VA-24-00002 Dunckley

**Project Name: VA-24-00002 Dunckley Zoning Variance**

**Proposal:** The proposal requests a 14-foot reduction to the 15-foot side yard setback required by KCC 17.30A.050 to accommodate an existing structure.

# EXHIBIT MAP

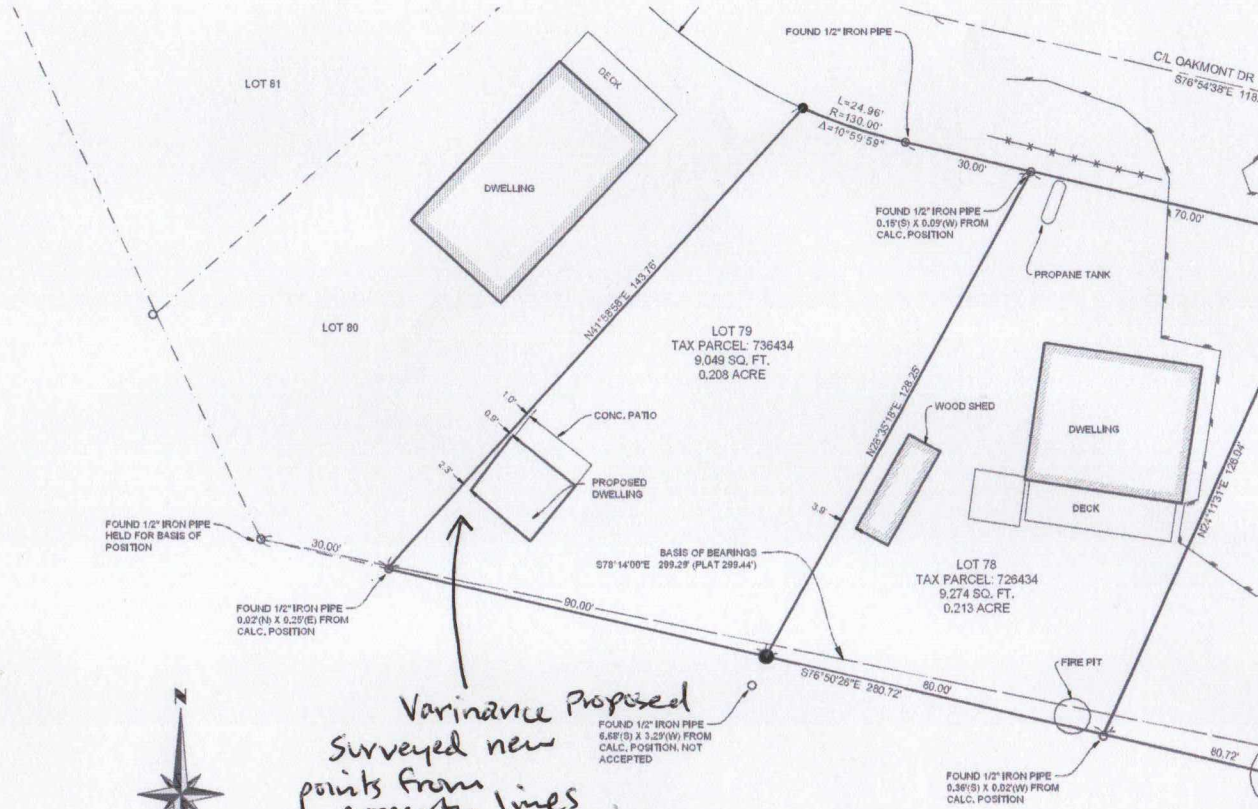
The Structure was modified from a shed and bringing in electricity and hooking up to water without following compliance to submit an architectural request form prior to any modification to the property. The owner had not filed for permits and plans with Kittitas County in modifying the shed into a living structure with also adding deck/hot tub etc.

The homeowner and those working on the structure were approached during this modification concerning submitting the appropriate request. There was no survey done and compliance to the 15-foot variance. The structure is currently not in compliance to that ruling.

Thank you for the opportunity to provide comment on this application. A building permit will be required to remodel the structure and bring it into compliance with current building codes. Due to the high snow load at the parcel, building plans will be required to be prepared and stamped by a Washington State licensed architect or engineer.

Due to the close proximity to the property line, additional fire separation is required. Openings in walls are not allowed if the property line is less than 3 feet from an exterior wall. Roof overhangs or any projections are not allowed less than 2 feet from a property line. Additional fire resistance rated construction is required for walls that are less than 5 feet from a property line or less than 3 feet if the structure has an automatic sprinkler system.
